From: Bruce Taunton
Sent: 06 March 2014 10:04
To: Planning.Responses
Subject: RE: Planning Consultation on: WA/6/14/

Grid Reference: 497346 105781
Description of Works: Change of use of store to single dwelling with porch extension & alterations. This application is a departure from the development plan

From: Anita Gardner
Sent: 07 March 2014 12:13
To: [REDACTED]
Subject: WA/6/14 - Walberton House, The Street, Walberton

WALBERTON HOUSE
THE STREET
WALBERTON BN18 0PJ
CONVERSION OF STORE
TO COTTAGE
BLOCK/SITE PLAN
FOR NICKI SHALE-HESTER

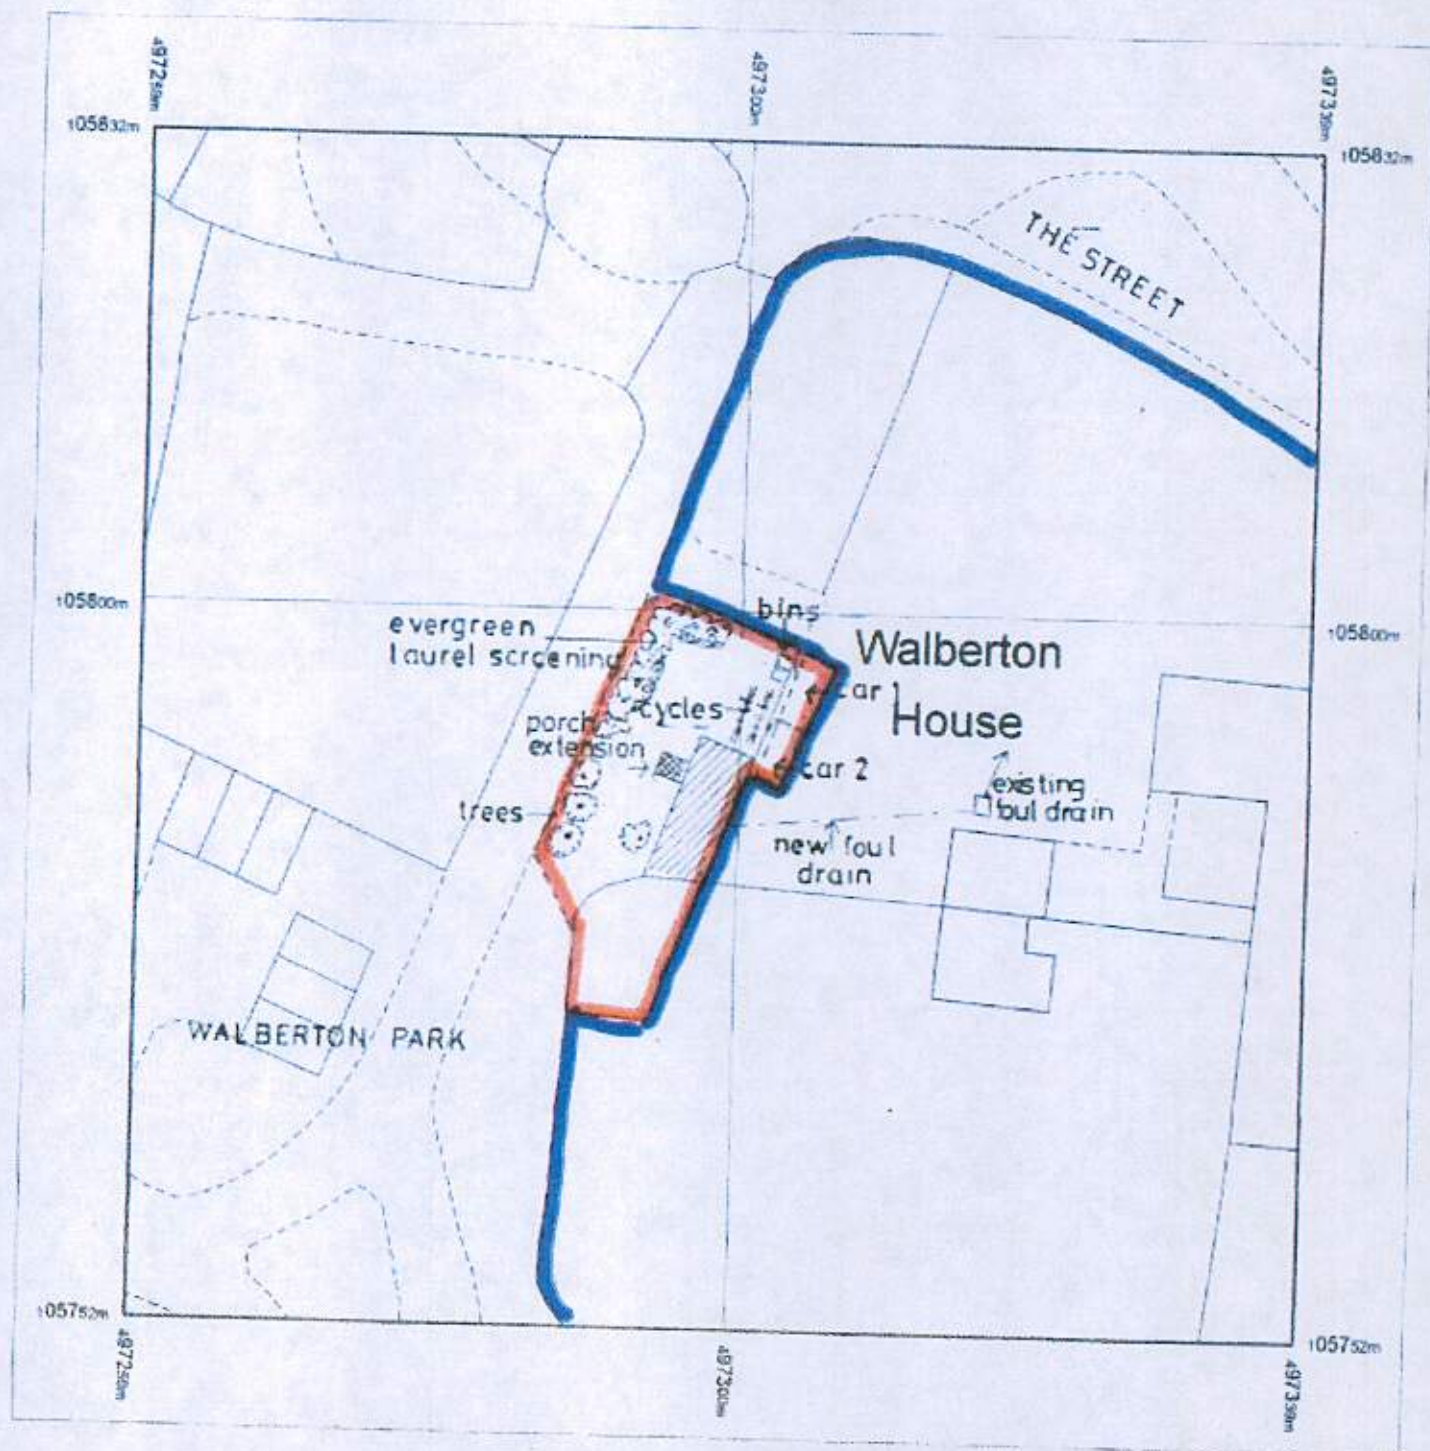
I refer to the above application. I note from the layout that the 2 parking spaces are located the other side of a security gate to Walberton House and that no pedestrian access is indicated to either the eastern side of the building or through the existing boundary wall. I would therefore appreciate clarification as to how it is envisaged these spaces will be accessed and utilised. Is it possible to make pedestrian provision? The matter is being raised in letters of representation.

As you will appreciate the existing dwelling is accessed by both vehicles and pedestrians using the same double security gates. The two parking spaces for the new dwelling will be accessed in exactly the same way and pedestrians will also use the gates as per the existing arrangement to access the parking spaces so an additional gate is not required. This will help maintain security for both the existing dwelling and the proposed one.

This arrangement was accepted as part of the earlier approval and was also not raised at that time. Originally going way back the parking spaces were shown on the land adjoining the access drive to Walberton Park, but were moved inside because of the neighbour's representations.
